Re: State Significant Development 6724 – 60 – 78 Regent Street, Redfern

SJB Planning has been engaged by the owner of No. 80 – 88 Regent Street, Redfern to review the State Significant Development (SSD) application No. 6724 for the proposed student accommodation at No. 60 – 78 Regent Street, Redfern.

Re: Submission – SSD 6724-2014, 60-78 Regent Street, Redfern

1.3 SHADOW ANALYSIS - IMPACT ON 80-88 REGENT ST  
DAYLIGHT ACCESS

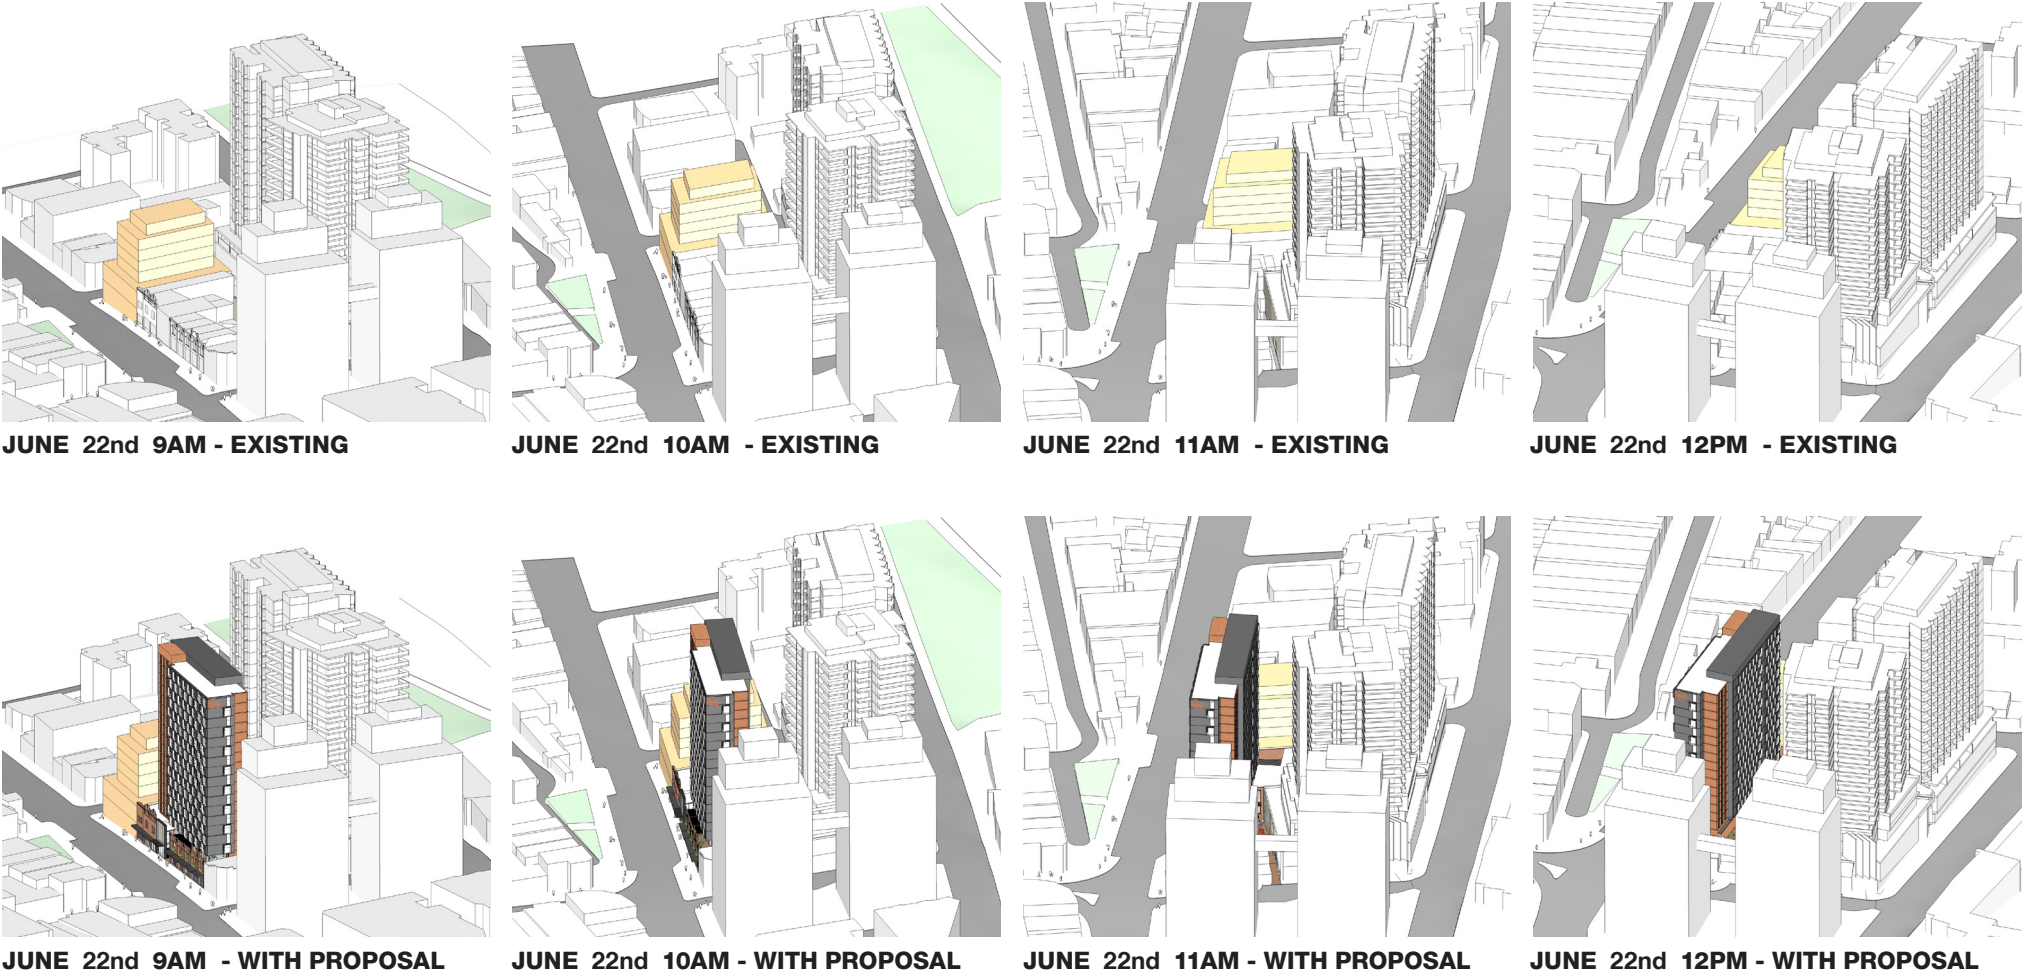
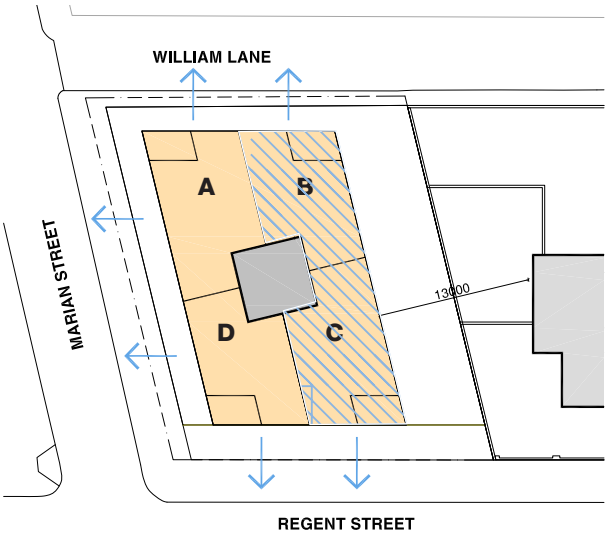
While in principle, we do not object to this reasoning, it is essential that the variation does not diminish the development potential of No. 80 – 88 Regent Street, particularly in terms of ensuring adequate solar access to apartments proposed as part of any future application. Furthermore, the variation to the tower setback controls should be considered within the context of the entire block, including No. 80 – 88 Regent Street, and potentially the block to the south to ensure a consistent built form response along this section of Regent Street. This is also important for ensuring an equitable distribution of built form across SEPP MD sites bounded by Regent Street and Gibbons Street.

Again as previously noted, variations to the controls should not compromise the development of No. 80 – 88 Regent Street in terms of ensuring appropriate daylight access and amenity to apartments within any future proposed residential flat building.

## SHADOW DIAGRAMS

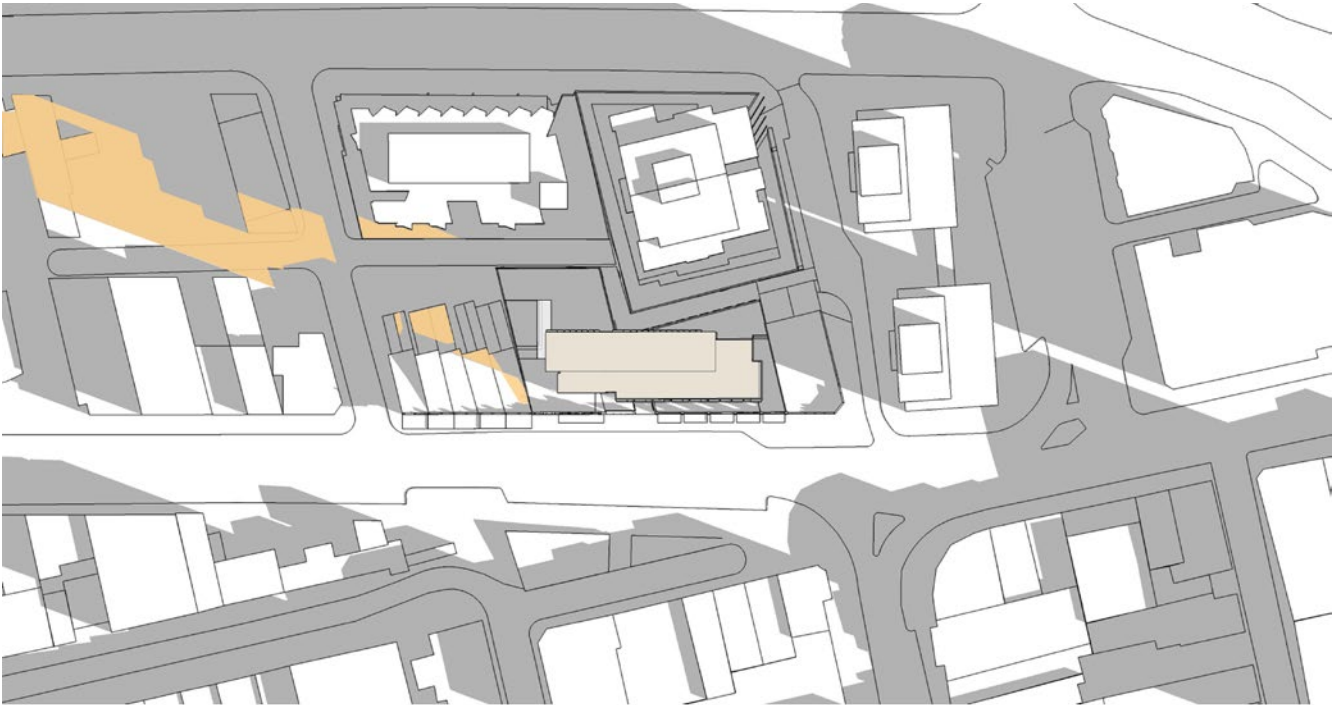
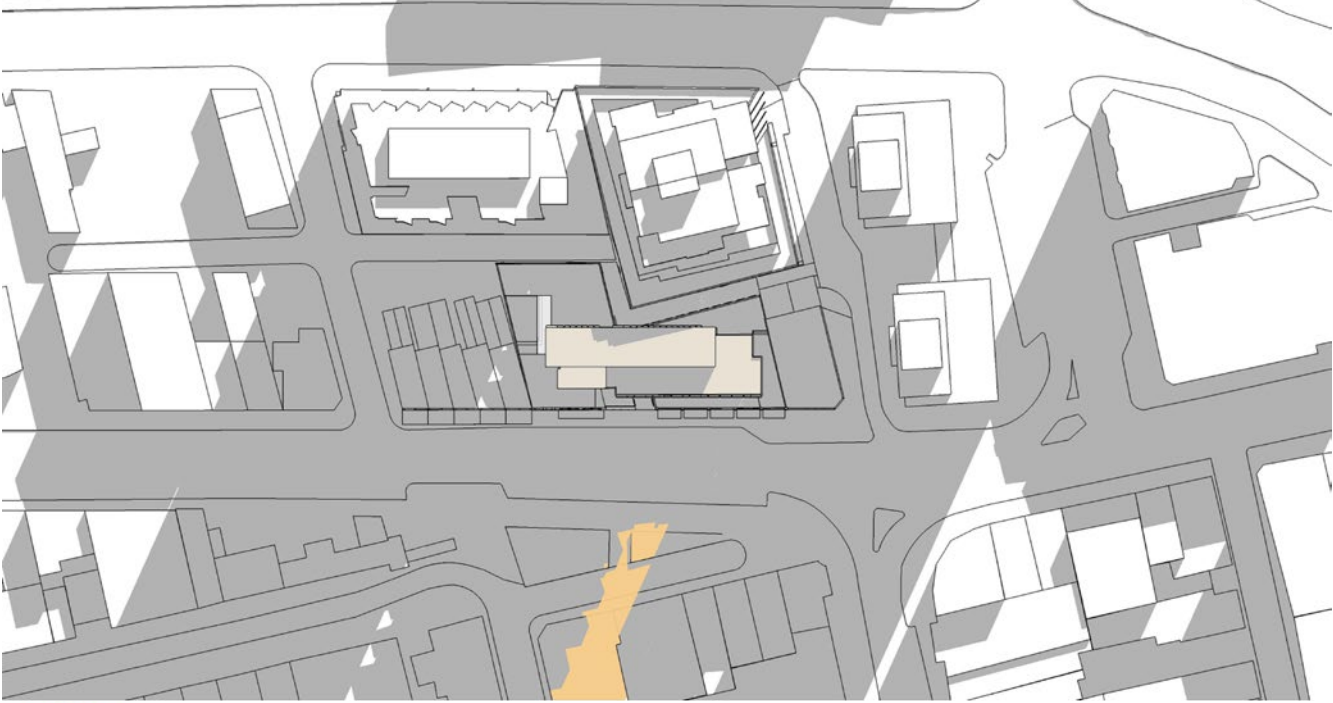
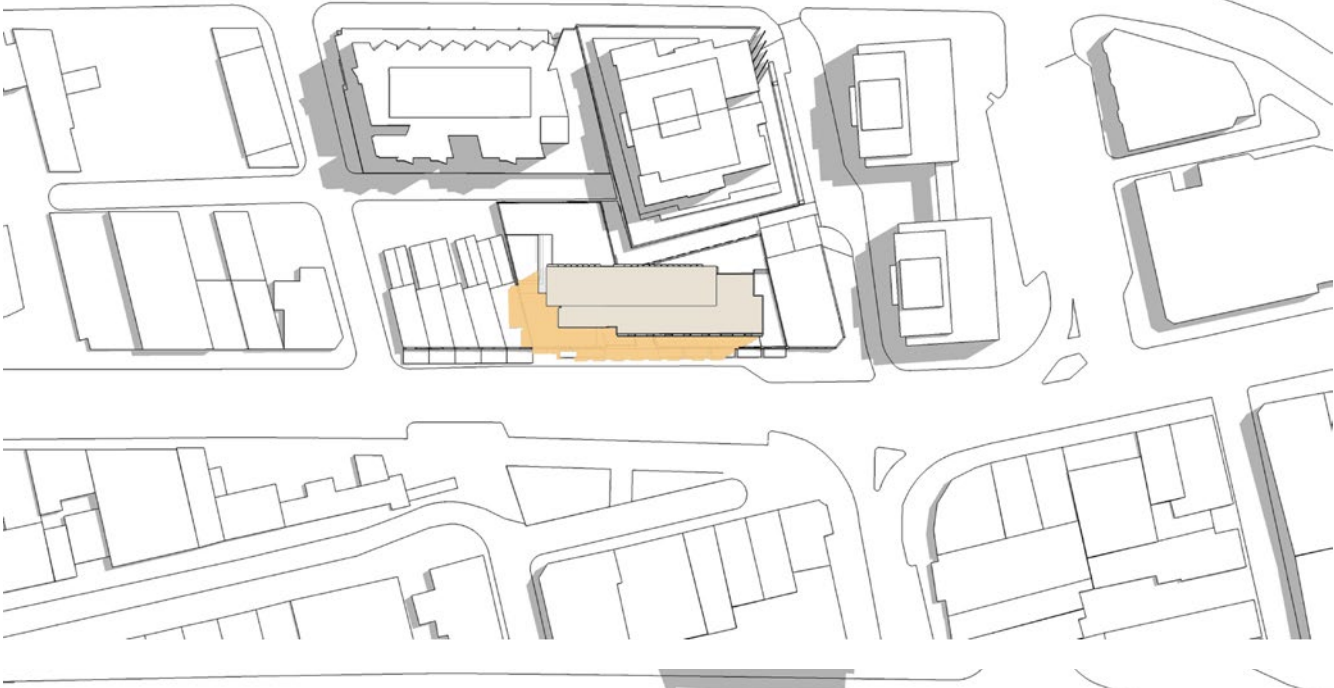
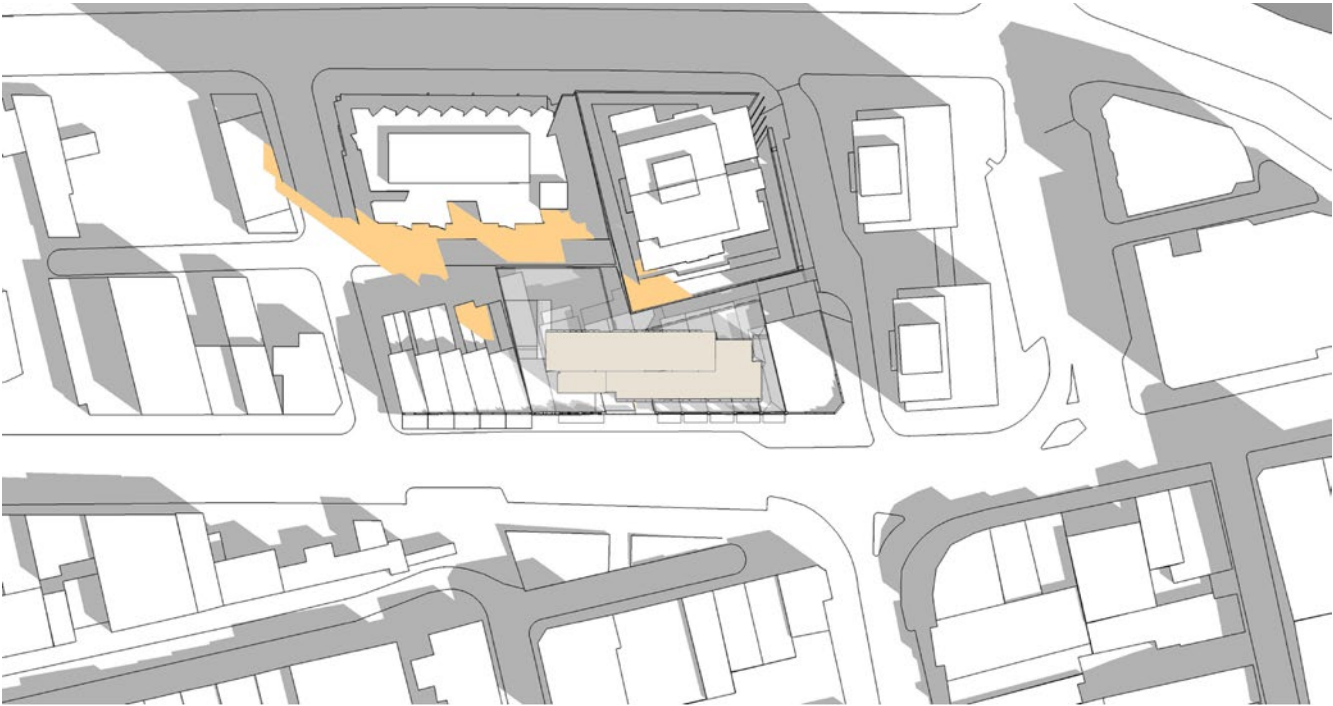
The Shadow Diagrams enclosed with the Design Report demonstrate that the proposed development would eliminate the remaining remnant of solar access to those dwellings on our client's site located on its south-eastern corner. Solar access is presently only available during the early morning period prior to approximately 11am during the summer solstice and equinox. The Application would appear to eliminate that remaining solar access for those dwellings.

Limited information has been provided in order to assess that impact. In particular, more detailed overshadowing elevation diagrams have been prepared for 7-9 Gibbons Street but not for our client's property. Neither has sufficient information been provided to conclude whether the impact arises out of necessity or poor design, having regard to the Planning Principle for solar access found in *The Benevolent Society v Waverley Council* [2010] NSWLEC 1082, and in particular where it is said: "Overshadowing arising out of poor design is not acceptable, even if it satisfies numerical guidelines. The poor quality of a proposal's design may be demonstrated by a more sensitive design that achieves the same amenity without substantial additional cost, while reducing the impact on neighbours." [emphasis added].
